## ASSESSMENT REPORT

### Mixed-Use Development, Ettalong Beach MP 09\_0121 MOD 3

This report is an assessment of a request to modify the Project Approval (MP 09\_0121) for a mixed-use development at Ettalong Beach in the Central Coast local government area.

Drawing Title
SHADOW DIAGRAMS - WINTER SOLSTICE

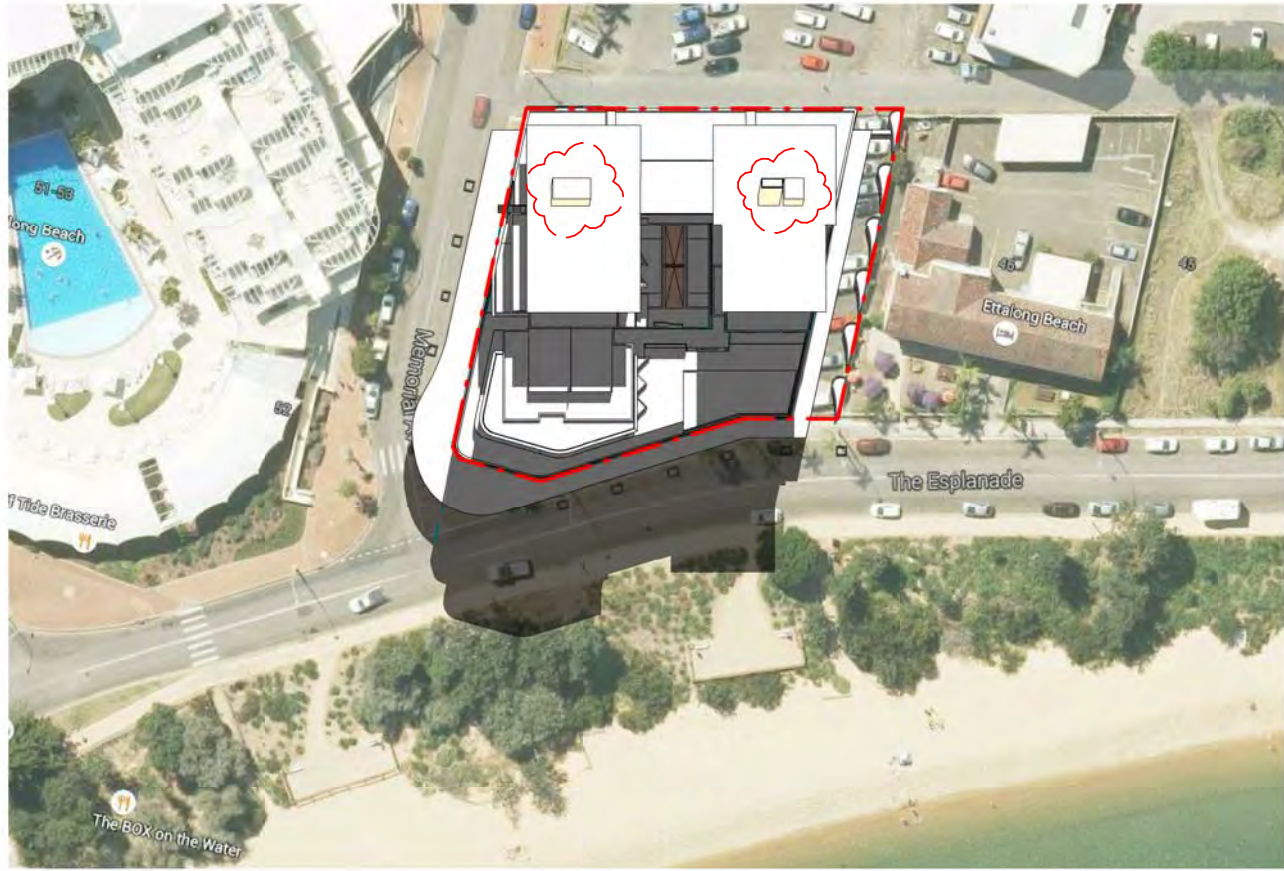
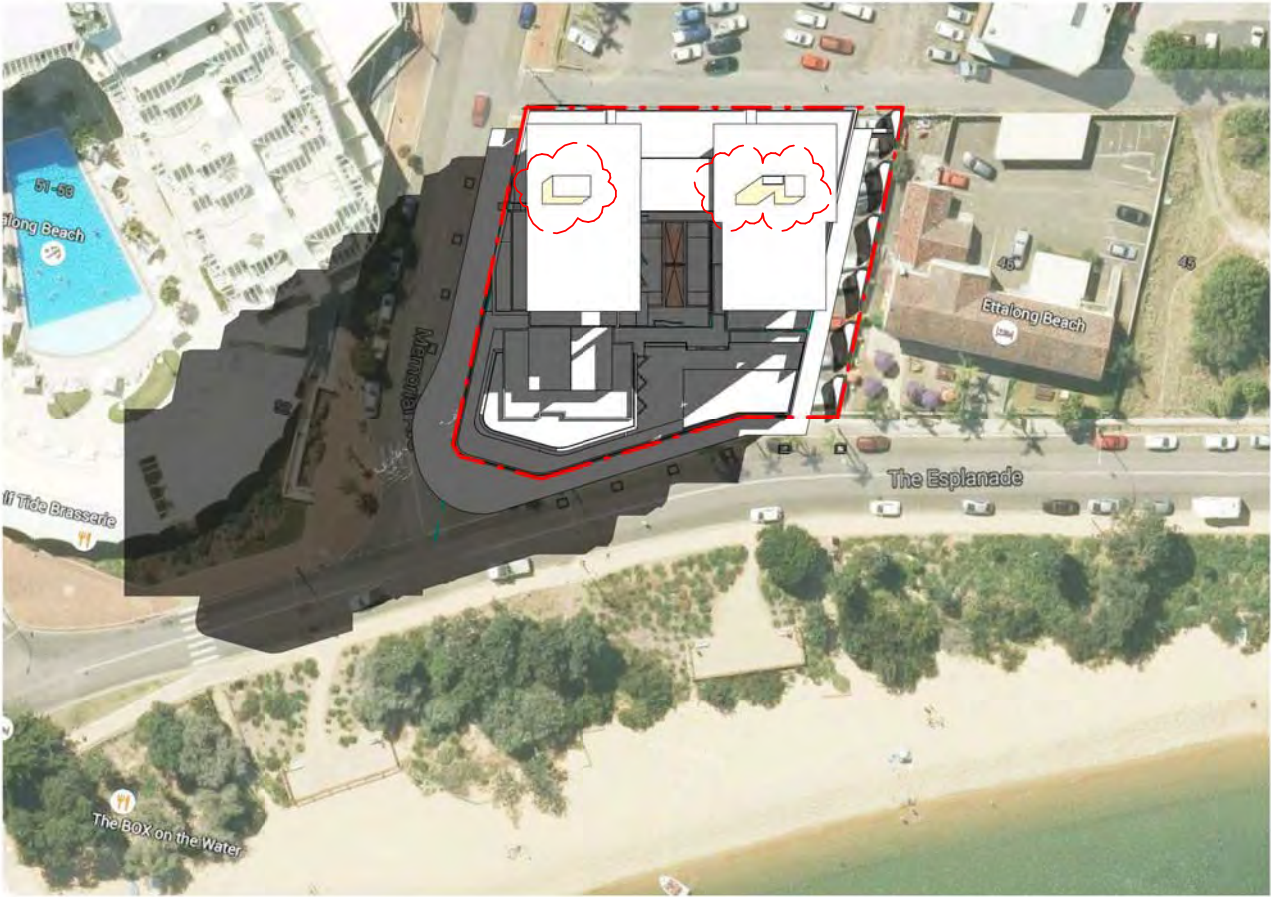
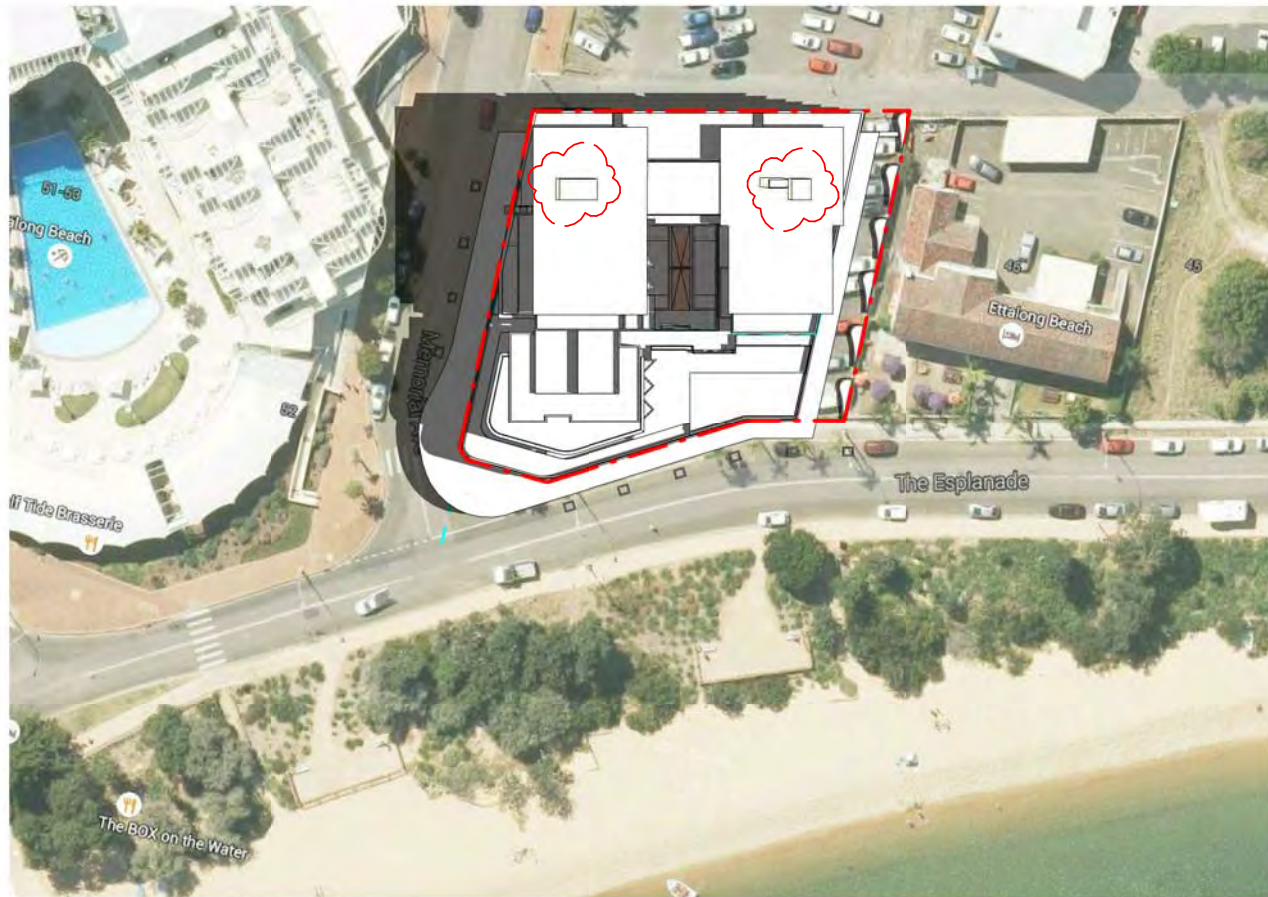
- the proposed increase in height is minor and relates only to the lift overruns
- the lift overruns are set back from the edge of the building, minimising visual impact from the street, as shown in **Figure 8**
- the additional shadows associated with the overruns are contained within the building footprint and would not have any impact on surrounding properties or public open space
- the proposed height is consistent with the original approval.

1 SIGHT LINE DIAGRAM - MEMORIAL AVE

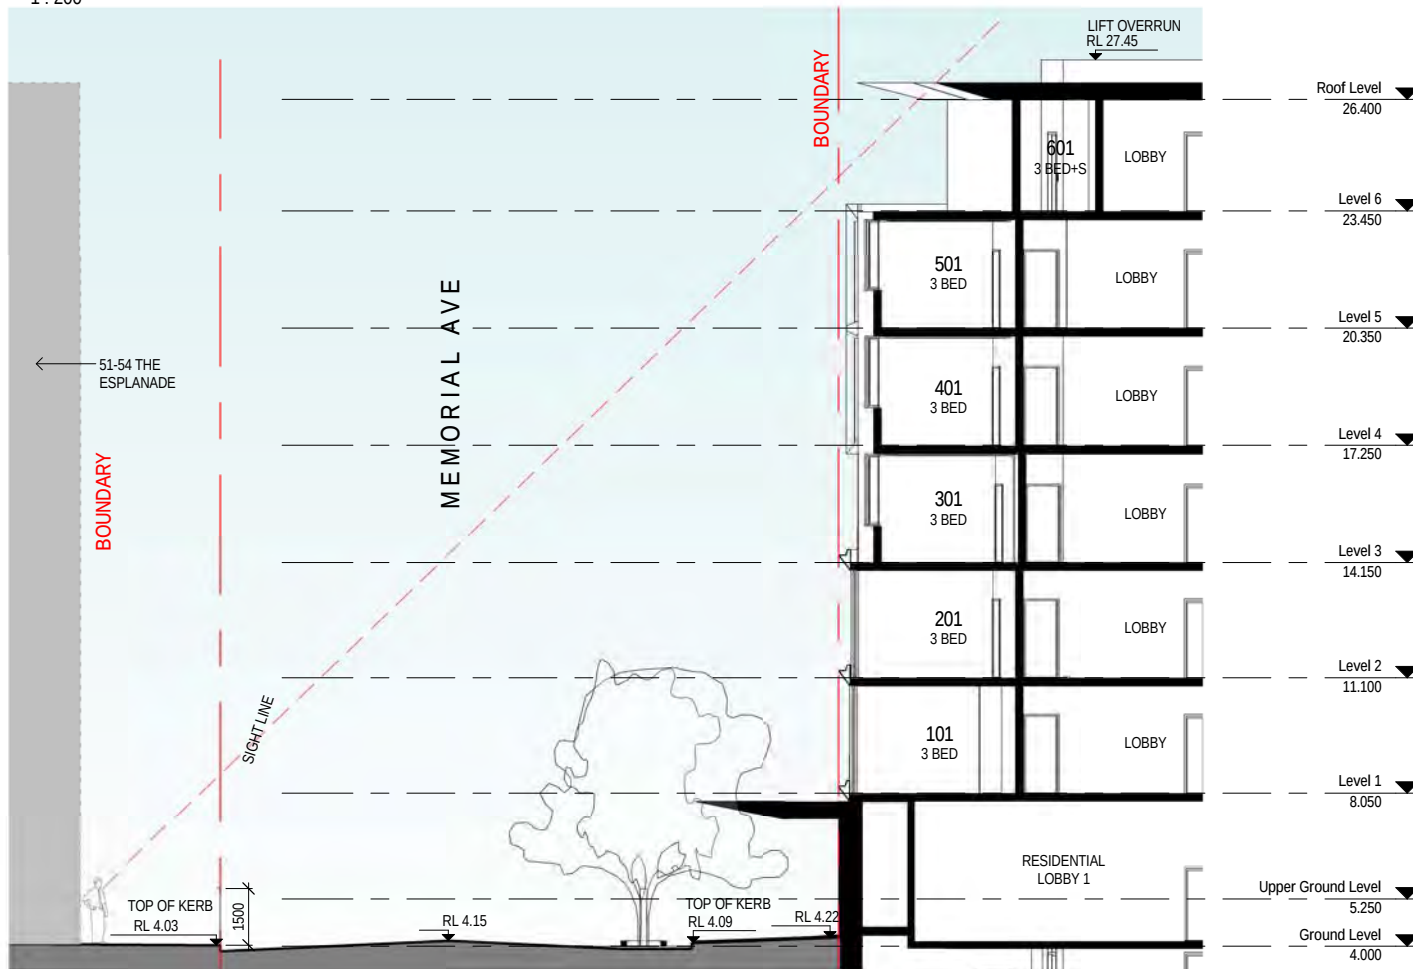
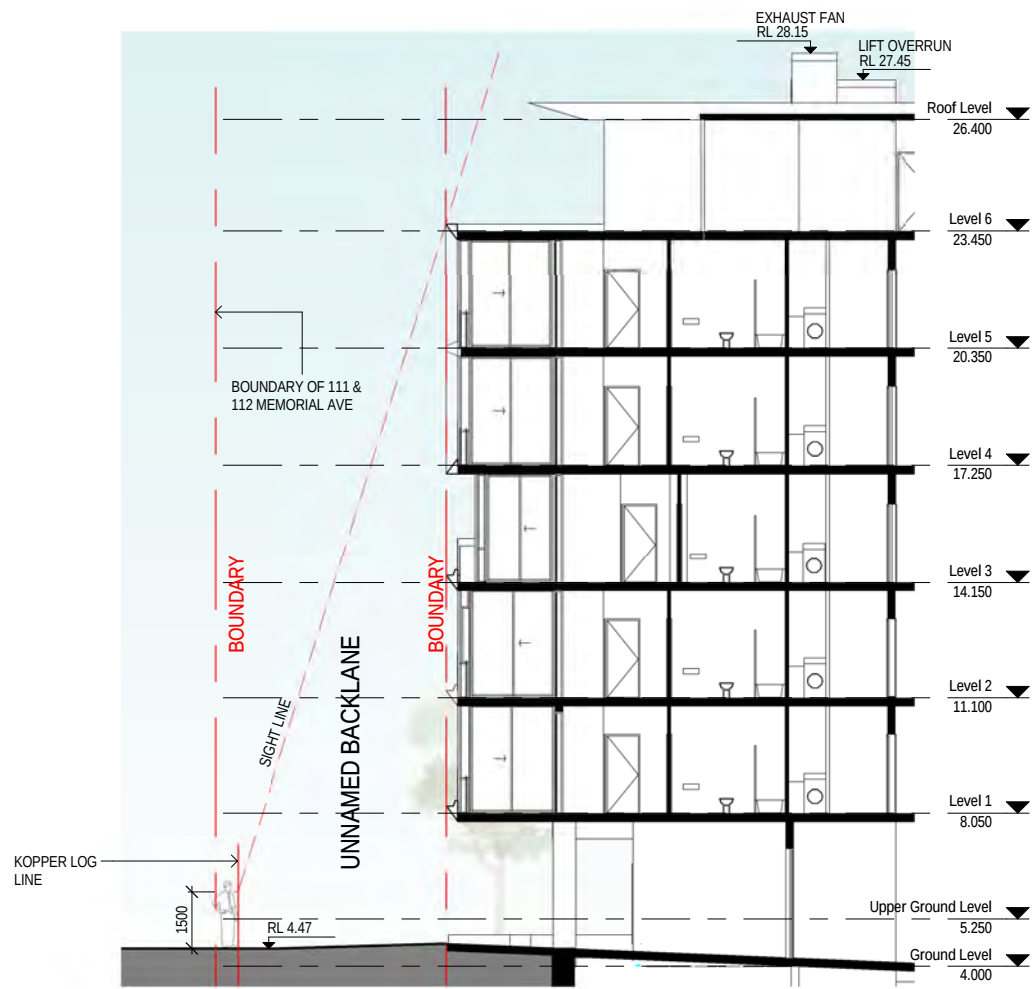
The proposal seeks approval for lift overruns associated with lifts 1 and 2, and the proposed lift 3. This would increase the height of the building within these areas by 0.6 m and result in a total height of 23.45 m. The Department notes the maximum permitted height for the site under the Gosford Local Environmental Plan 2014 (LEP) is 11.5 m.

On this basis, the Department is satisfied the additional height associated with the lift overruns would not result in any unacceptable visual, amenity or overshadowing impacts beyond those already assessed and approved.

APPENDIX A.4 RETAIL BIN TRAVEL PATHS

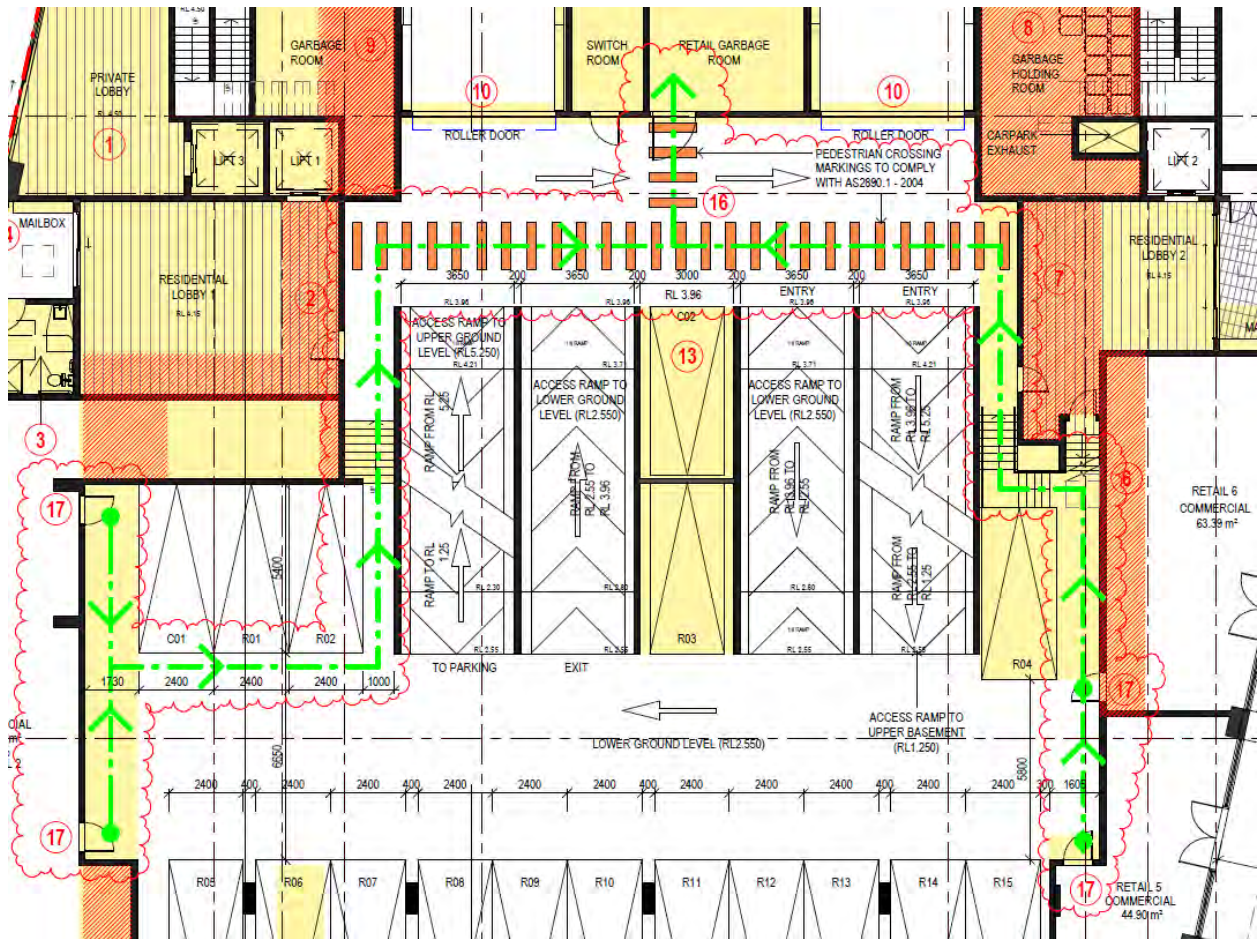
The proposal seeks to remove internal access corridors from the retail spaces to the waste storage room, and incorporate this space into the retail tenancies. Council requested that a revised Ground Floor Plan be submitted, indicating the path of travel from the internal access of each retail space to the waste storage enclosure.

Council reviewed the updated documents, and advised the Proponent's response addressed its concerns, however Retail Tenancy 4 should be provided with internal access to the waste storage room.

Council responded, noting the arrangement is not desirable and may impact the future use of the tenancy, but did not request further amendments to the plans.

The Proponent submitted a revised Waste Management Plan and updated Architectural Plans addressing Council's requests (see **Figure 6**).

The Department acknowledges Council's concerns regarding access to the waste room from the tenancies, but notes the arrangements have not altered from the approved development. The Department also notes subsequent approvals for uses within the tenancies will be required to address waste storage and ensure appropriate measures are implemented. The Department therefore considers the proposal is acceptable in terms of access to waste storage.
